CITY OF ALBUQUERQUE

RE: **McDonalds – McMahon Market Place, Lot 7** **A11-D011B**
SW Corner of McMahon & Fineland NW PE Stamp dated: - N/A
Conceptual Grading & Drainage Plan - Site Plan for Building Permit *cmnt LTR*

Based upon the information provided in your submittal received 07-26-2013, the above referenced **Conceptual Plan is approved for Site Plan for Building Permit.**

ISAACSON & ARFMAN, P.A.
 Consulting Engineering Associates
 128 Monroe Street N.E.
 Albuquerque, New Mexico 87108
 Ph. 505-268-8828 www.isaacson.com
 1998 CG-101.dwg Dec 02, 2013

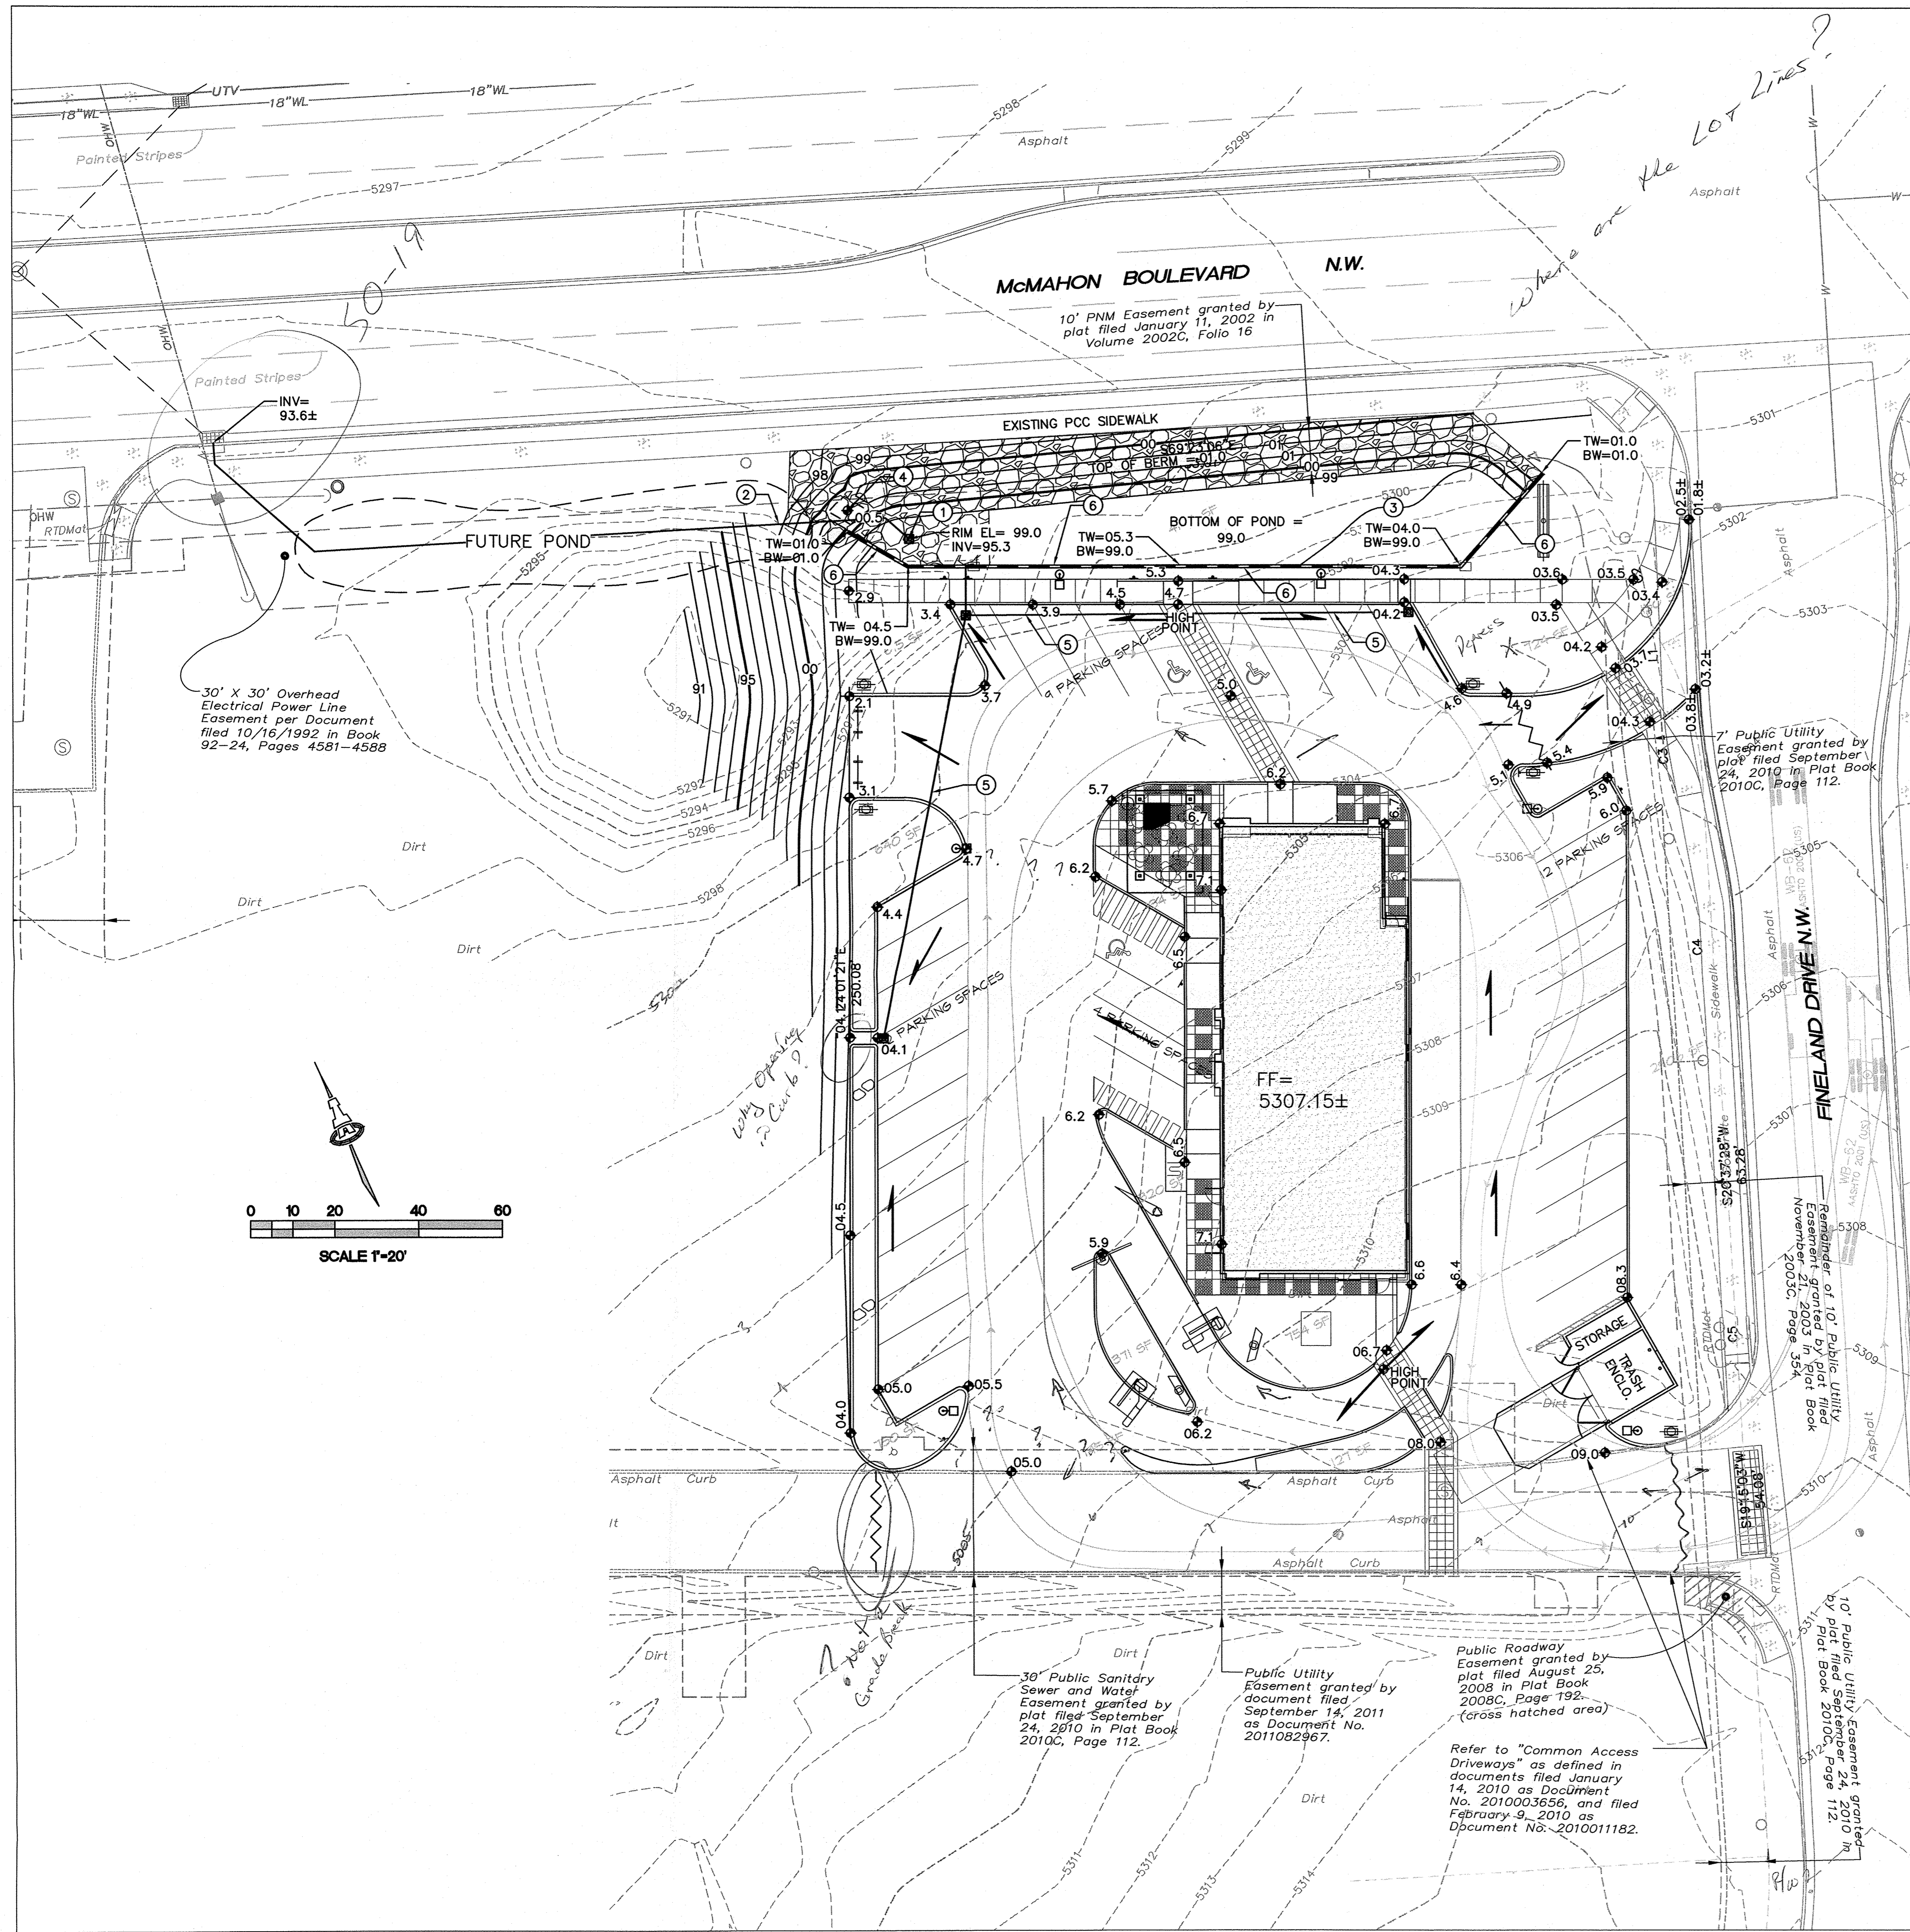
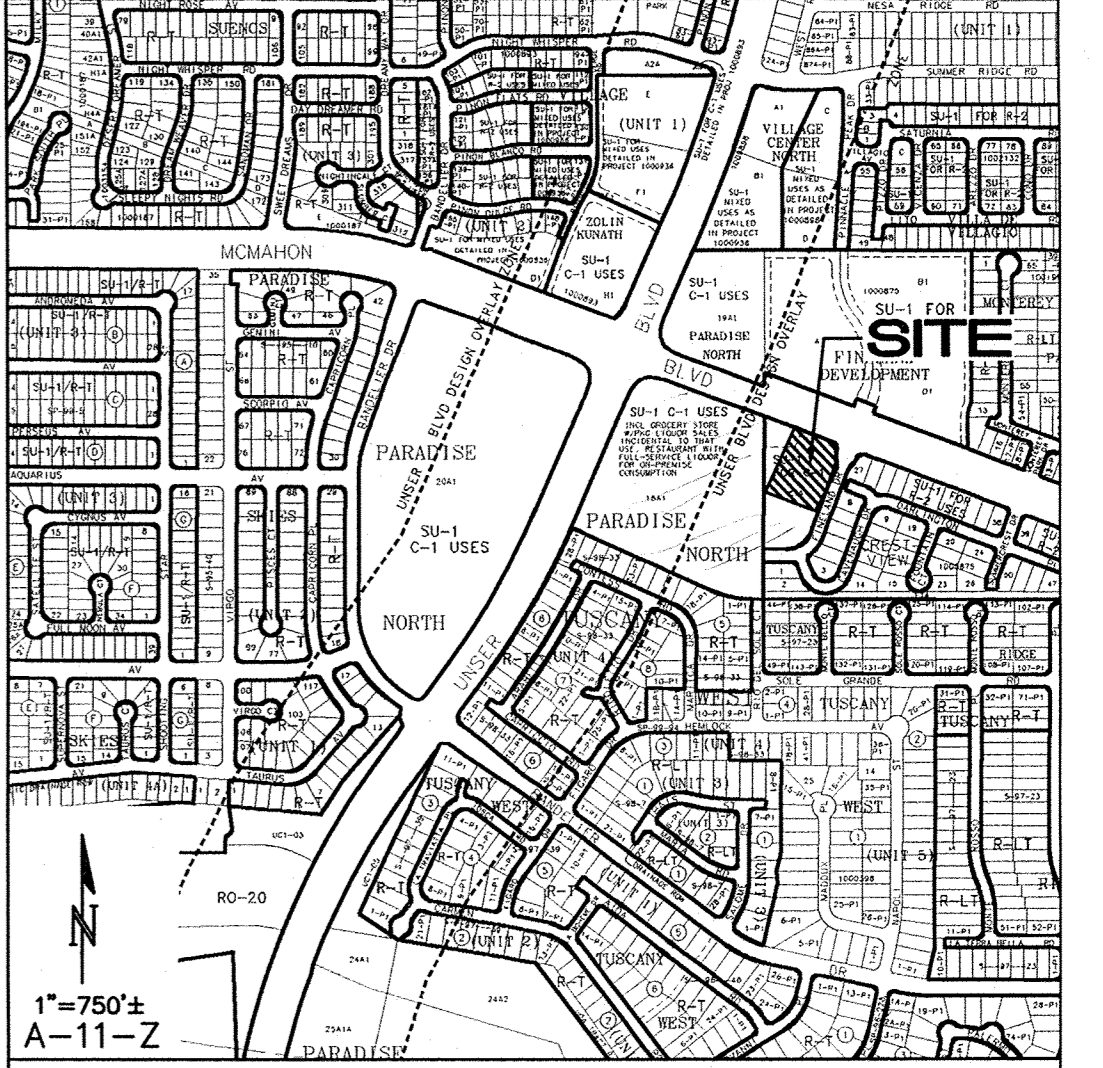
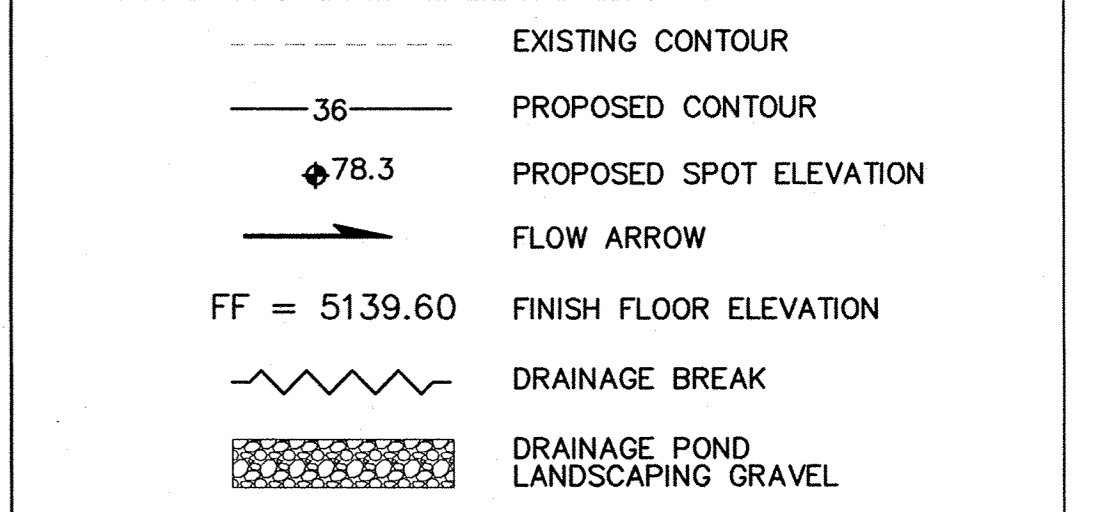
- The Master Drainage Plan for the McMahon Marketplace predicts a developed runoff of 52.55 cfs, but limits the developed discharge for the overall site to 41.55 cfs. Lot 7 will need to absorb a portion of the required detention. Provide calculations and size the pond and outfall accordingly.

- Your discharge from Lot 7 is proposed to cross Lots 5 & 6, before entering the public storm inlet on the south side of McMahon Blvd. The design for the inlet connection must anticipate future discharge from the remaining lots, and the SO-19 connection needs to be sized large enough to accommodate all of the flow, with just one inlet connection.

- Have easements been granted for the cross lot drainage and ponds along McMahon? Show them on the plan.
- Depress landscaping on the site to provide Water Harvesting.

- If ponds along McMahon are to encroach on the existing PNM easement, ensure that depths do not conflict with buried utilities.
